Question:	Question to:	Question:	Response:
Q1.1.6	Lincolnshire County Council	<p>Central Lincolnshire Local Plan Review</p> <ol style="list-style-type: none"> 1) Can Lincolnshire County Council please provide an update in respect of the progress of the Central Lincolnshire Local Plan Review and its progress towards adoption? 2) Should this change during the Examination Lincolnshire County Council should inform the Examining Authority (ExA) of any change in status at its earliest convenience. 	<p>Whilst this question is more appropriate to West Lindsey District Council it is confirmed that the Central Lincolnshire Local Plan was adopted in April 2023.</p>
Q1.1.21	Lincolnshire County Council, Nottinghamshire County Council, West Lindsey District Council, Bassetlaw District Council, Environment Agency, Natural England, Historic England, Lincolnshire Wildlife Trust, and any other Interested Party.	<p>Management Plans</p> <p>The Applicant has submitted the following outline management plans:</p> <ol style="list-style-type: none"> i) Outline Battery Safety Management Plan [APP-222] ii) Framework Construction Environmental Management Plan (fCEMP) [APP-224] iii) Framework Operational Envir

FIGURE TITLE
Outline Landscape Masterplan
Sheet 1 of 6

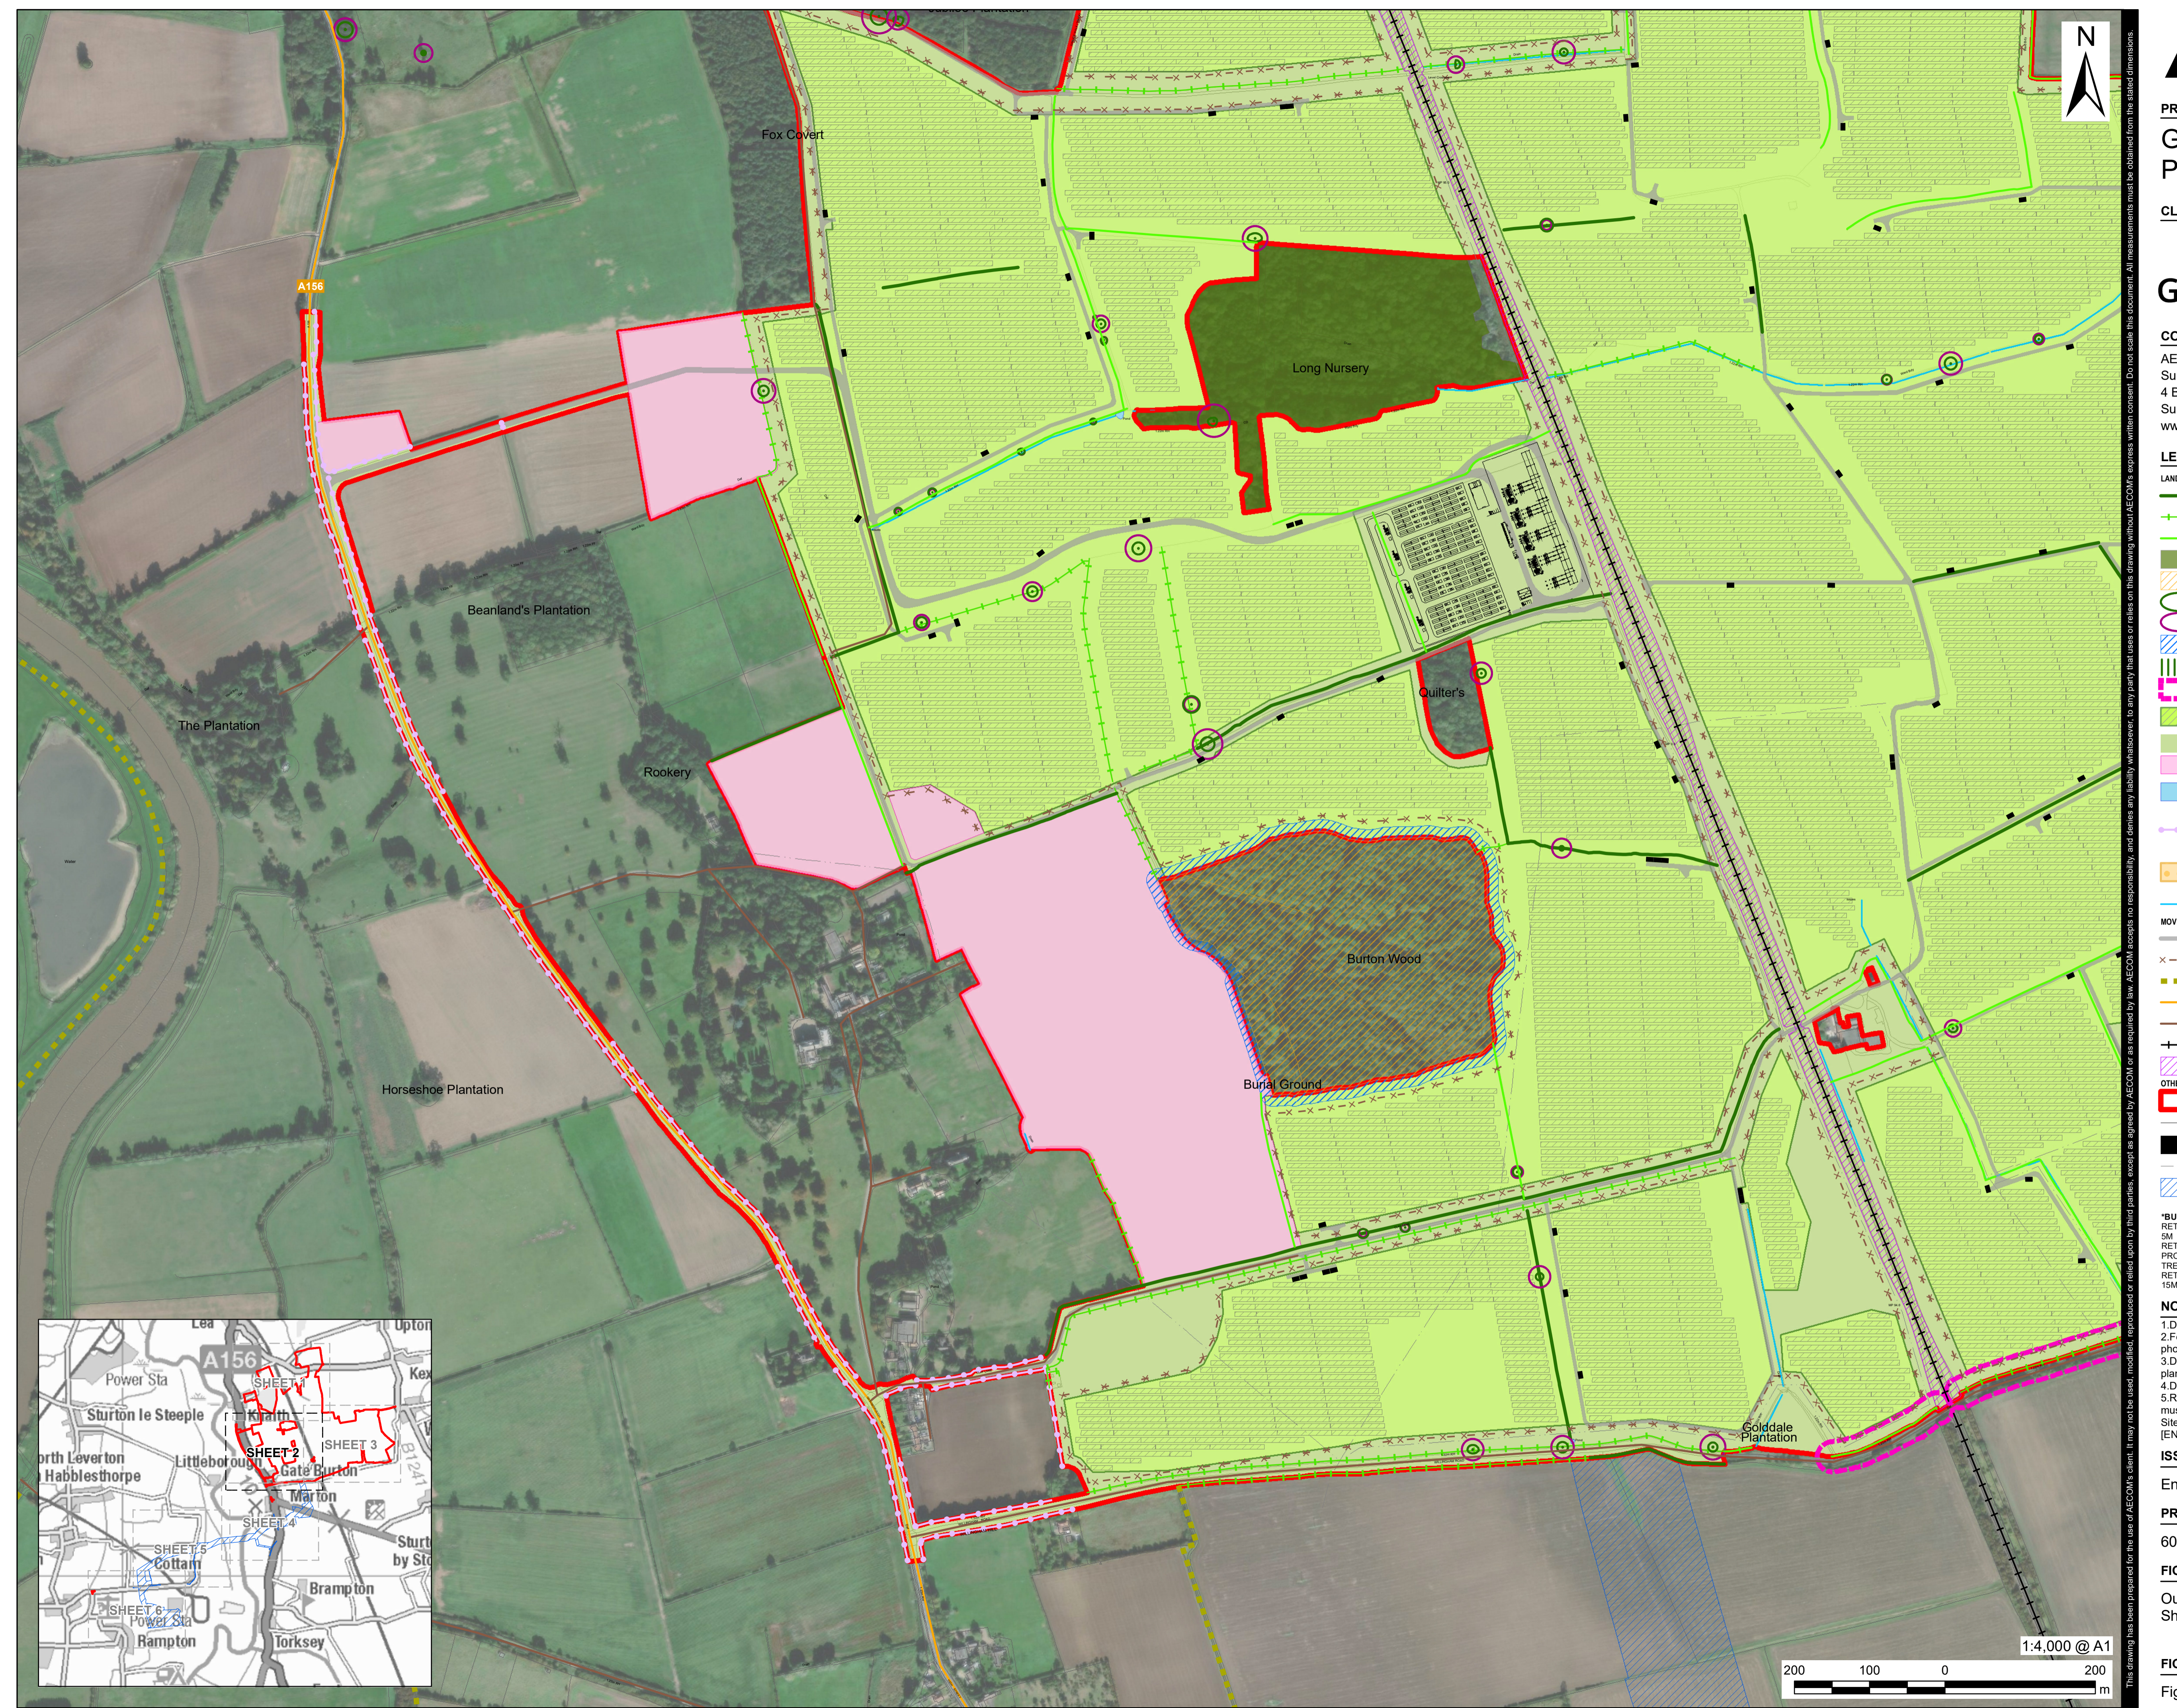
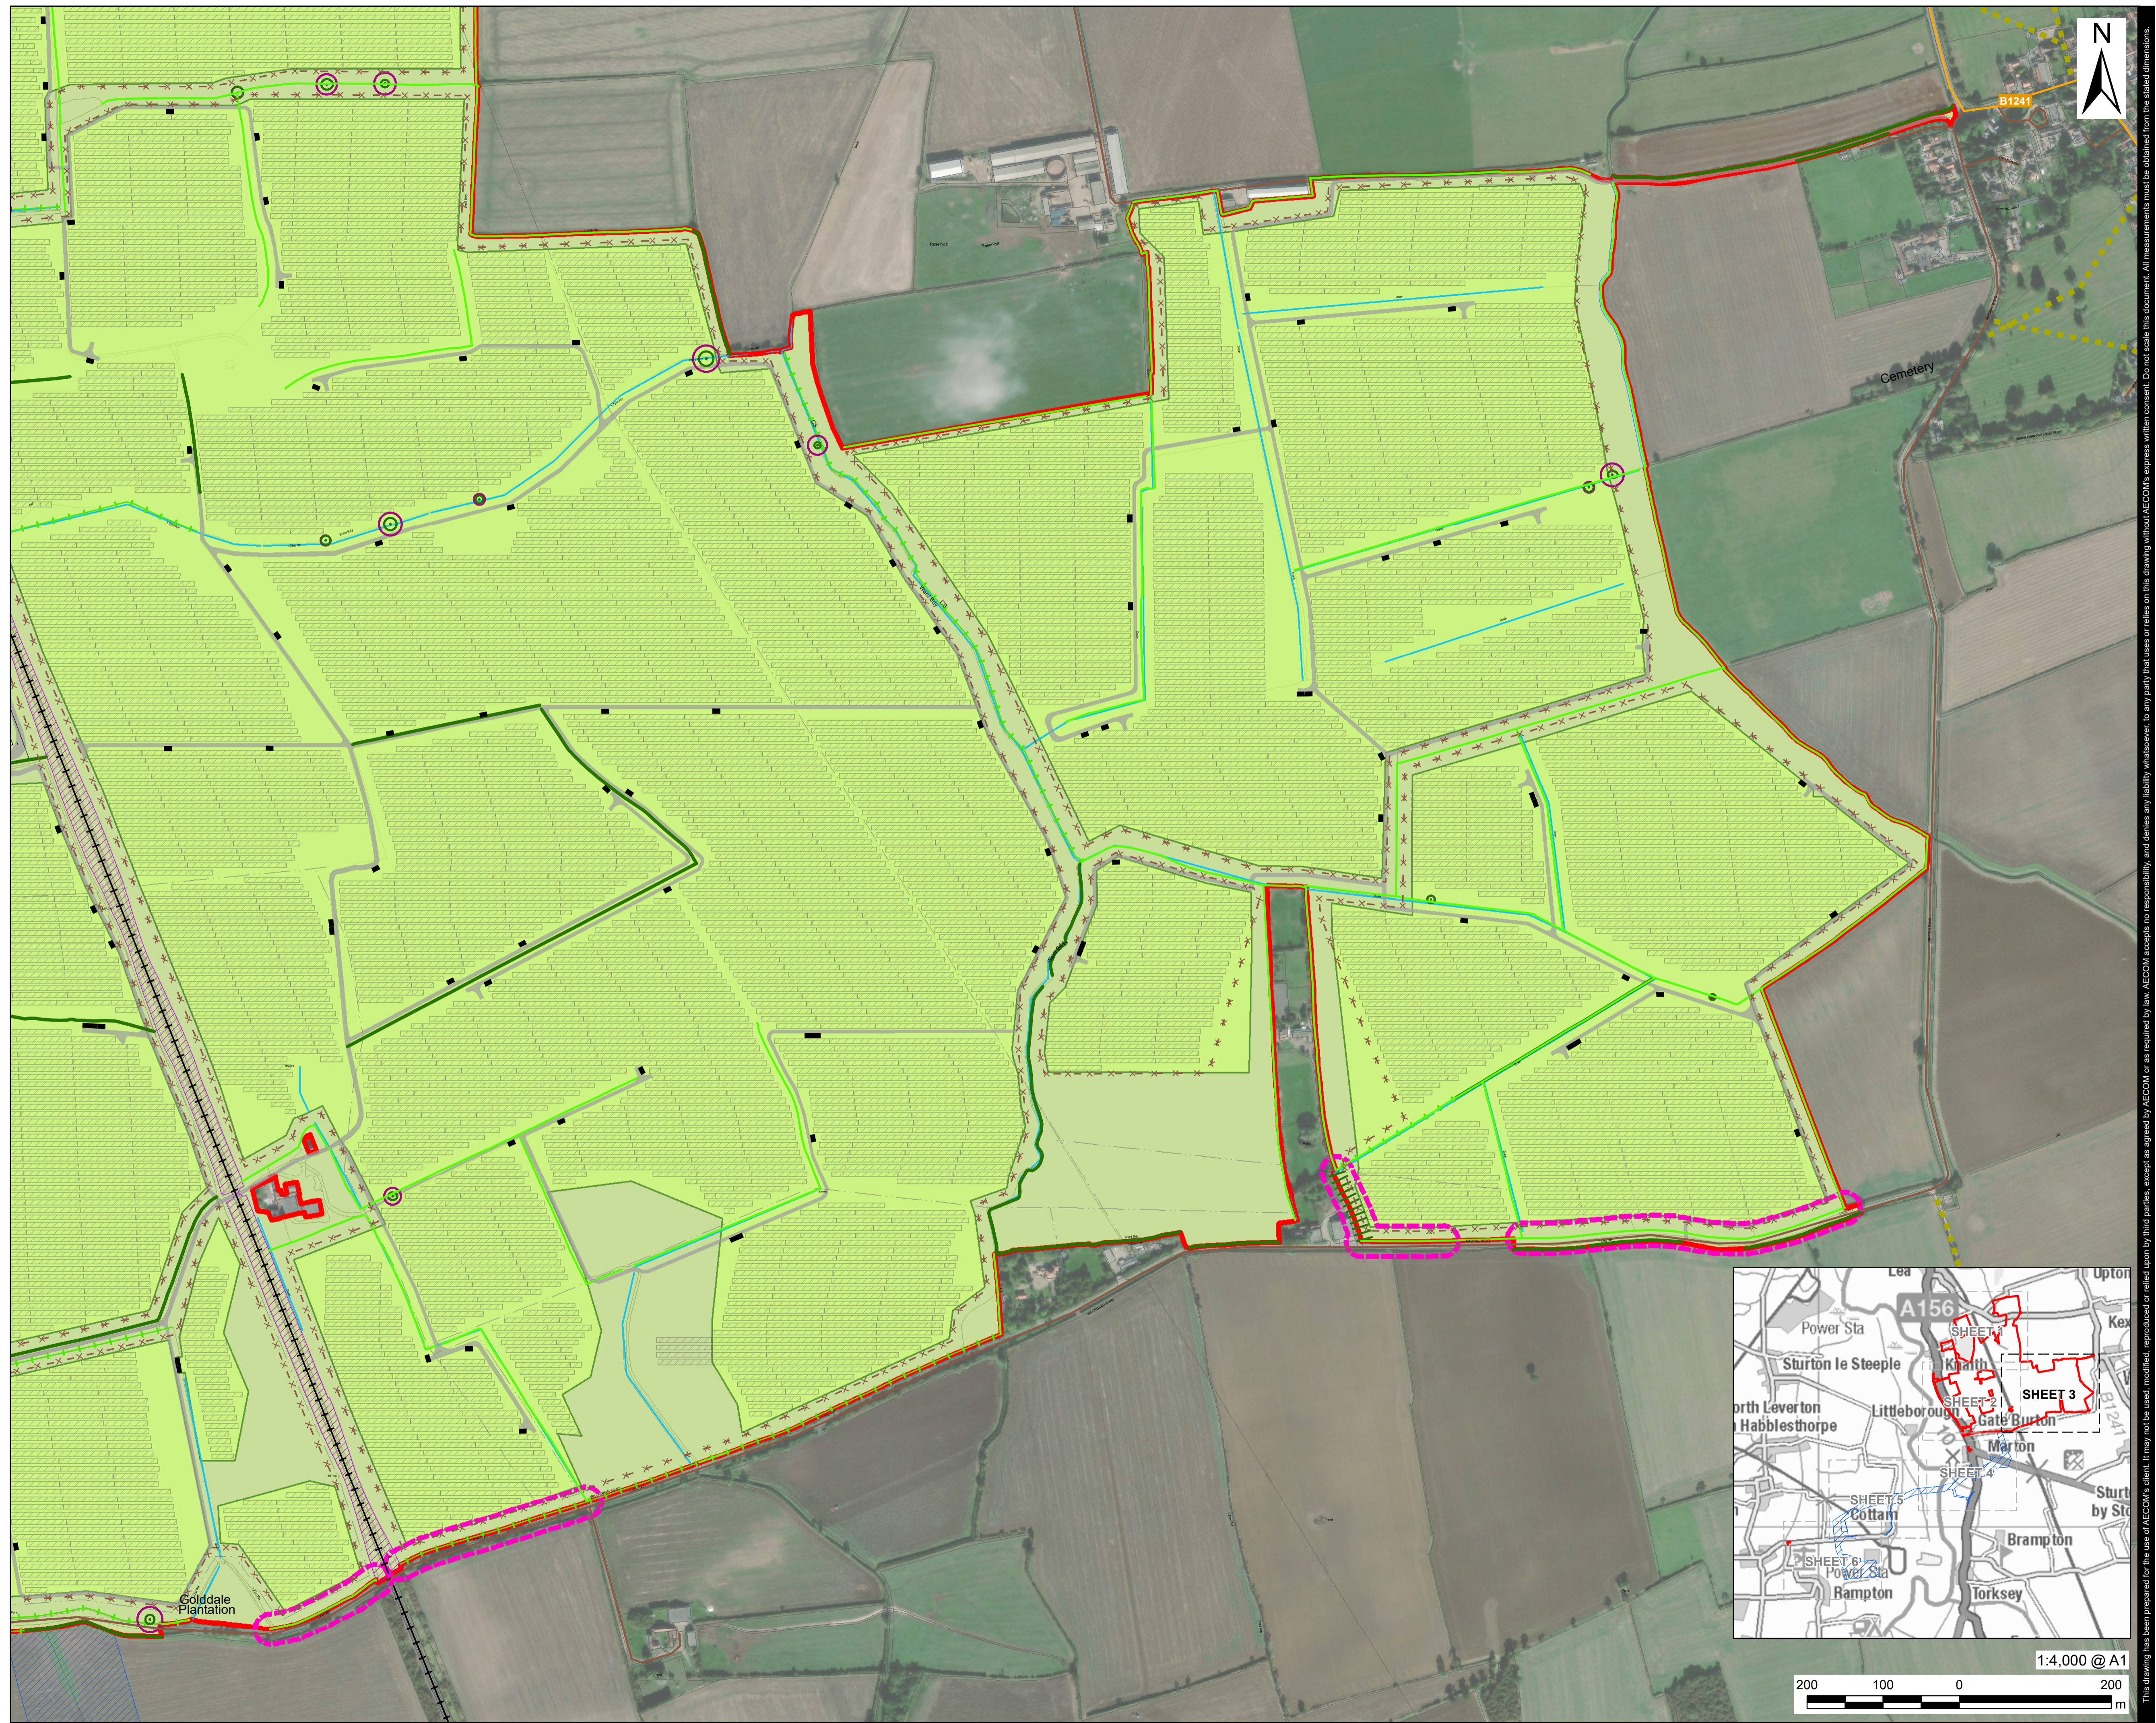
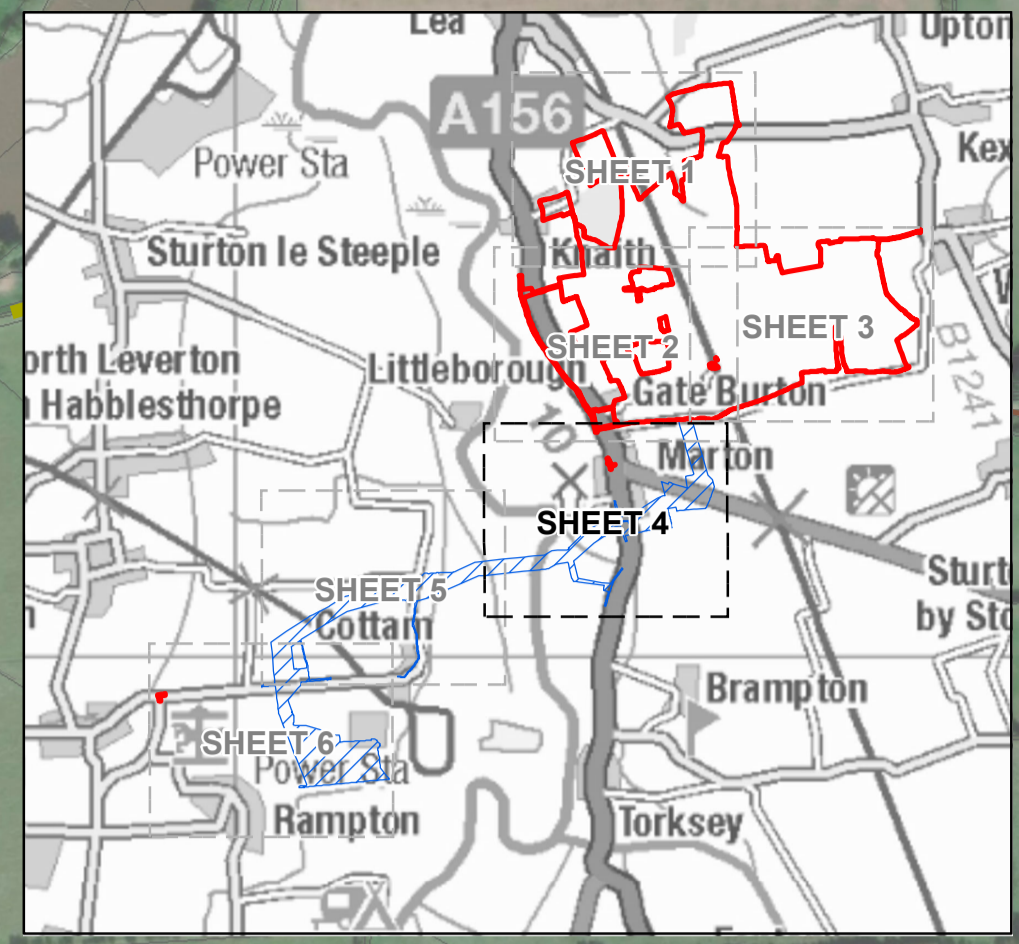
The success of the landscape mitigation to meet the objectives laid out in the management plan to integrate and screen proposals, promote conservation and protection of the environment and ecological and habitat diversity is highly dependent upon the successful management and maintenance of the new planting, as well as protection of exiting trees and hedgerows. The maintenance operations provide an initial overview of operations; however we would expect the management plan be developed further and also last well beyond the initial 5 year period, particularly if landscape and visual effects are being assessed at 15 years: the reduction in landscape and visual effects presented in the LVIA are based on the success of landscape mitigation. Similarly, any early planting should be secured and implemented at the earliest opportunity as effects are also reduced in the LVIA based upon the assumption these are in place and have established as planned.
